From: Jamie Brown [REDACTED]
Sent: 19 October 2021 09:31
To: Amy Myer <Amy.Myer@arun.gov.uk>
Subject: RE: R/203/21/PL - Booker Hall - URGENT COMMENTS NEEDED BY WSCC HIGHWAYS PLEASE

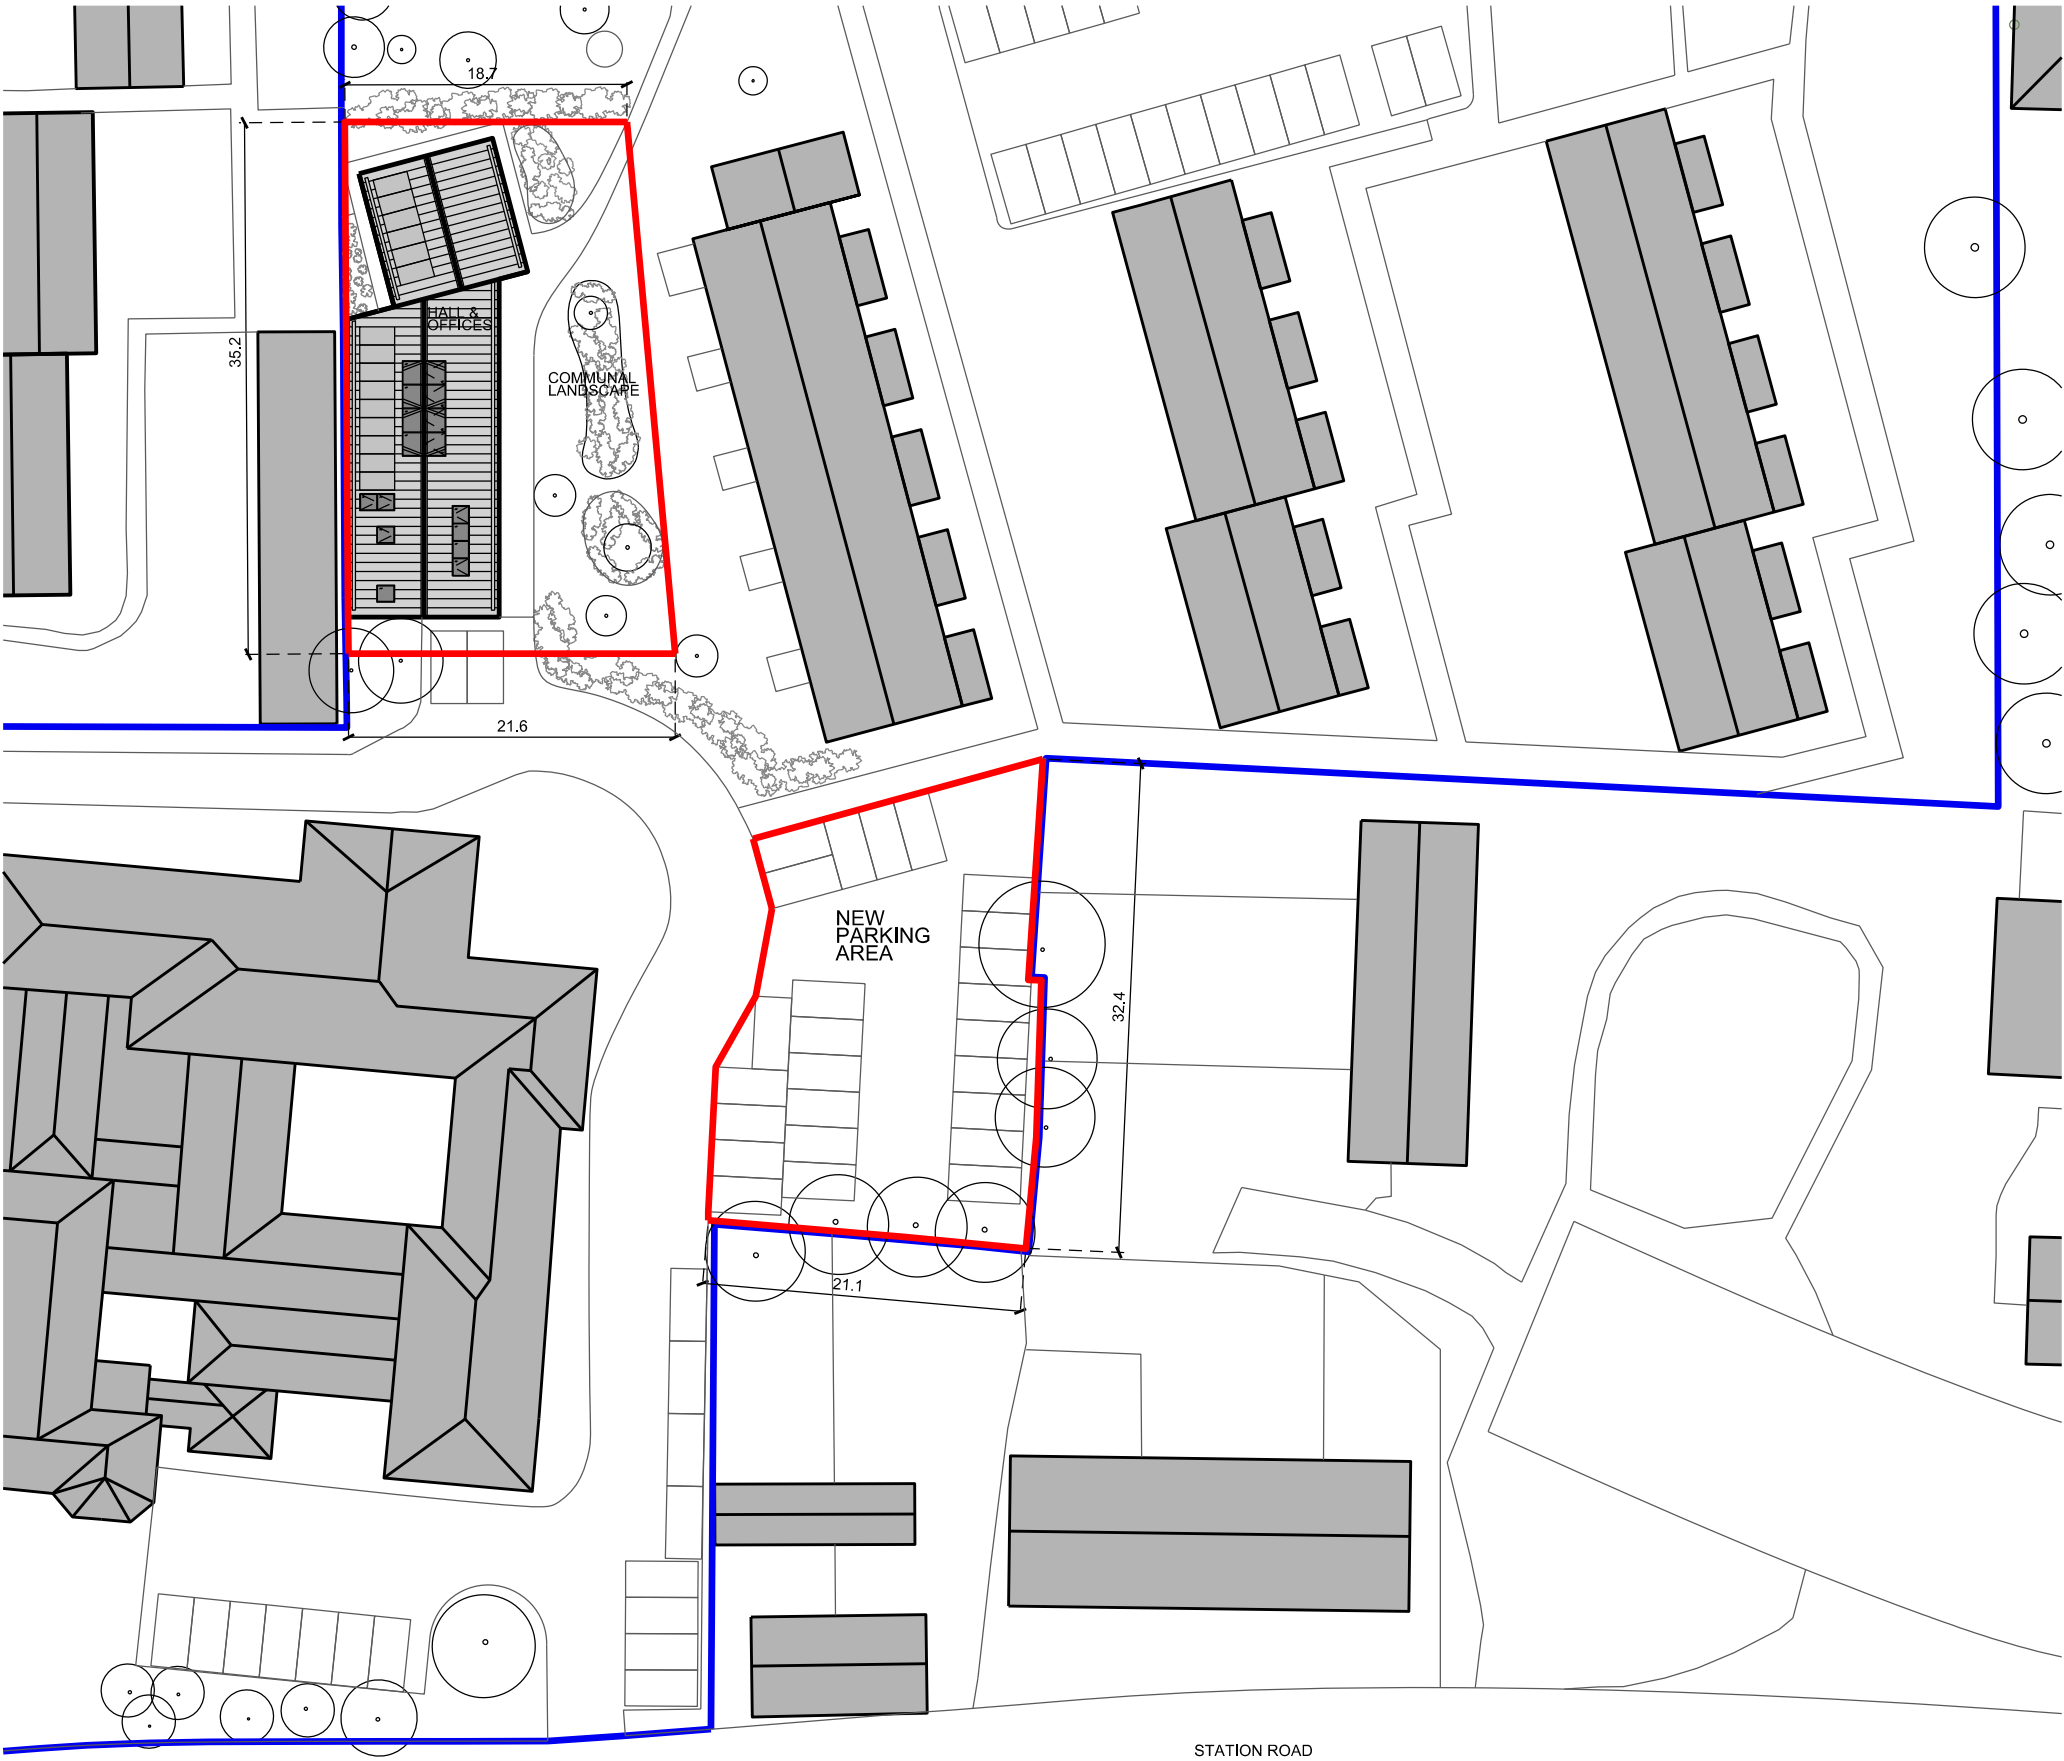
- The Parking Standards would be applied are LHA ones as shown in table 3.1 of the applicants Parking Statement. Looking at this the office part of the development would be subject to 7 parking spaces and the hall 10 spaces. The application proposes 25 spaces. On that basis I am satisfied the parking is sufficient.

In terms of standards the proposed the Parking Statement states that eight stands with 16 spaces are to be provided. However reference is made to 3 stands being required as part of the standards which is correct. Therefore it's a shame there are not more spaces but I think we would struggle to insist the go back to their original allocation.

- Agreed re the dwelling wording, 'use' would be more appropriate. These are standard conditions and I hadn't changed it. I have asked for the condition to secure the works including space markings of the proposed parking area, the condition covers this.

- Suggested Cycle Parking condition- *Cycle parking-No part of the development shall be first occupied until covered and secure cycle parking spaces have been provided in accordance with plans and details to be submitted to and approved by the Local Planning Authority. Reason: To provide alternative travel options to the use of the car in accordance with current sustainable transport policies.*
